20170038.1/1007A/R0/TA

Western Sydney Stadium - SoundPLAN Noise Emission Modelling

This letter presents the supplementary SoundPLAN noise emission modelling to address comments raised by the EPA in their letter dated 27 June 2017.

#### Rock Music Noise

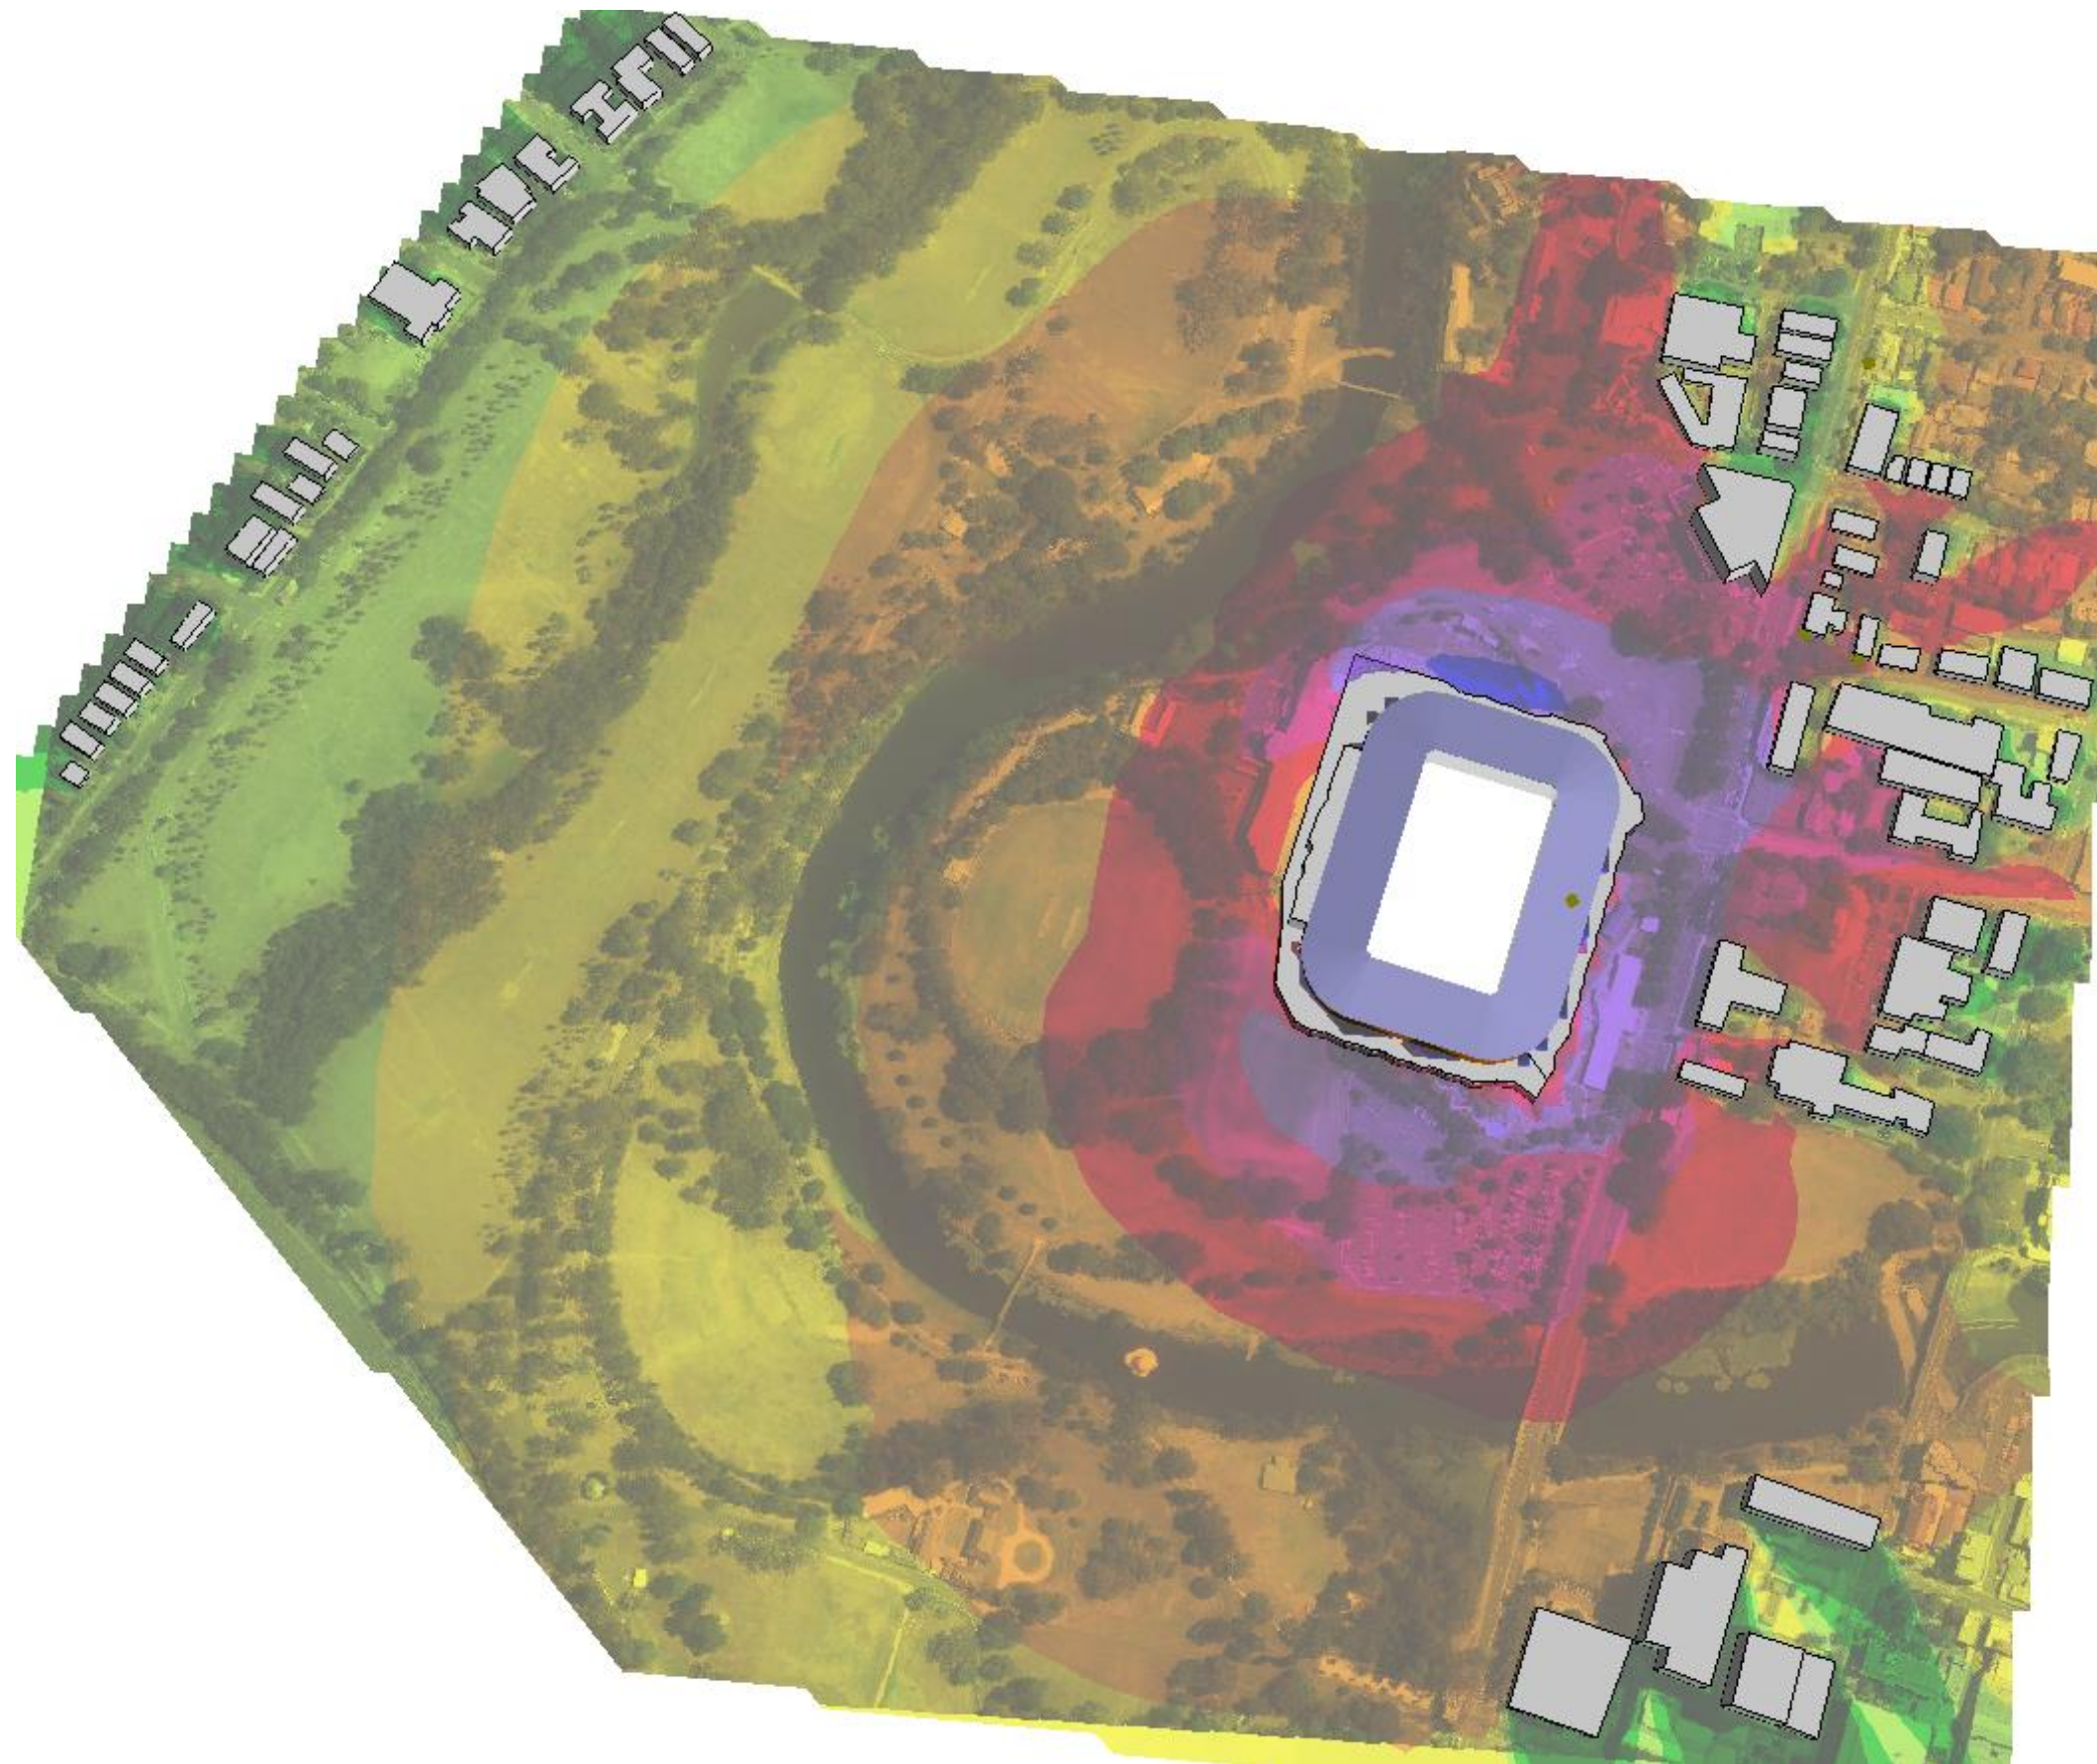
(a) provide a more detailed noise model of operational noise from the stadium, or other quantitative assessment, demonstrating that openings between seating tiers will not result in event noise being higher than predicted at sensitive receivers

The response to submissions did not demonstrate that all feasible and reasonable noise mitigation measures were included in modelling concert noise (for example, relocating the stage to face south, not north).

The openings between the seating tiers have been modelled and are presented as an isolated noise model in Appendix One. The predicted noise level contribution from the openings between the seating tiers is 64dB(A) at the nearest residential receivers in concert mode, 15dB(A) below the originally predicted noise level from the stadium as a whole, 78dB(A). As the contribution from the openings between the seating tiers is more than 10dB(A) below the predicted noise contribution of 78dB(A) from the main stadium, there is no increase in overall predicted noise level.

The stage has been relocated to the northern end (facing south). The results of this modelling are presented in Appendix Two. Modelling results indicate noise levels of 70dB(A) L_{eq} (including the contribution from the gaps between the seating tiers) for noise emissions during concert mode to receivers to the north. Previously these noise levels were predicted to be 78dB(A) L_{eq} with the Stage facing north.

The stage is now proposed to remain in this location, facing south, reducing noise emissions to the nearest residential receivers situated on O'Connell Street.
